Our Ref: F2012/00161

Attention: Director, Industry, Social Projects and Key Sites
Application No: SSD 6180

Re: Public exhibition of the EIS for Stage 2 of the Nelune Comprehensive Cancer Centre and Australian Advanced Treatment Centre (NCCC & AATC)

OVERALL LANDSCAPE PLAN

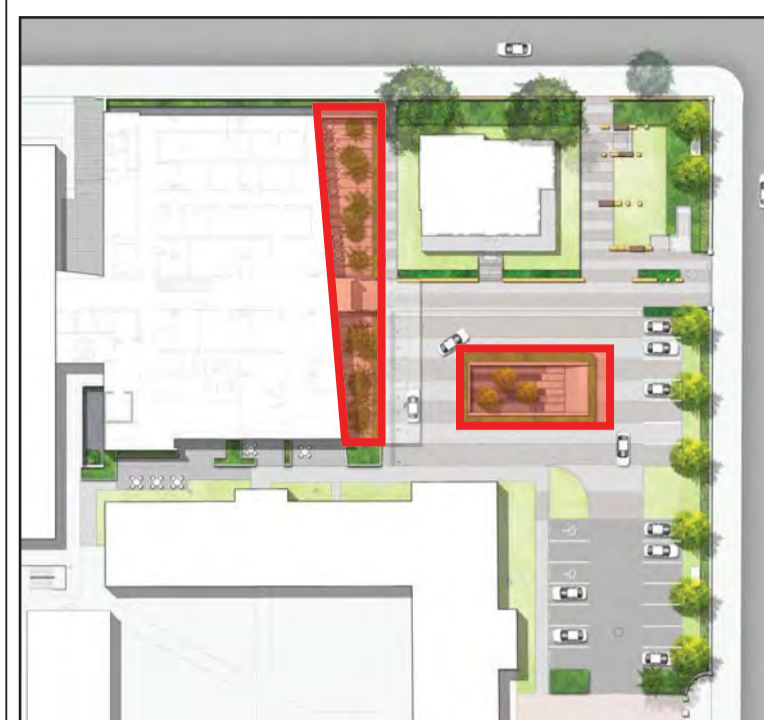
Coloured exposed aggregate insitu concrete paving is proposed for the forecourt plaza and major pedestrian walkways while simple treatment with asphalt paving is proposed for the parking court and access road. It is also noted that the banded concrete paving for the forecourt area has much wider interval width than the adjoining pedestrian space near the Superintendents Cottage and public park (as shown on the Landscape Plan). Council is concerned that this inconsistent paving treatment will have adverse visual and aesthetic impacts to the overall settings of the entire site.

The proposal notes that the Superintendents Cottage is to be surrounded by a raised lawn. There are serious concerns in relation to potential damage to the fabric of the Cottage which is likely to result from increased damp caused by raised soil levels and interrupted subfloor ventilation. The changing of the ground level around the heritage item will also adversely impact on the traditional siting and proportions of the building.

The north east pedestrian gate along the Avoca Street frontage is proposed to be widened, which involves relocating the existing sandstone piers, cutting the sandstone base and the metal palisades and replacing the existing single gate. The fence was dismantled and recorded prior to the commencement of Stage 1 works to avoid damage. It is critical to ensure the heritage significance of this pedestrian gate is not compromised through the widening process.

Council recommends that the paving treatment for the entire site be further considered to achieve a consistent paving pattern with high quality materials and finishes at such a significant location that visually complements the heritage buildings and the new contemporary medical facility.

The landscape aspect, which proposes raised lawn around the Superintendents Cottage is suggested to be revised, to provide level access from surrounding public domain and to ensure no increased risk of damp affecting the Cottage.

In relation to the proposed widening of the heritage gateway, Council requests details of the widened opening and use of any new gates be provided. Additionally, the original gate should be salvaged and stored, displayed or reused on site.
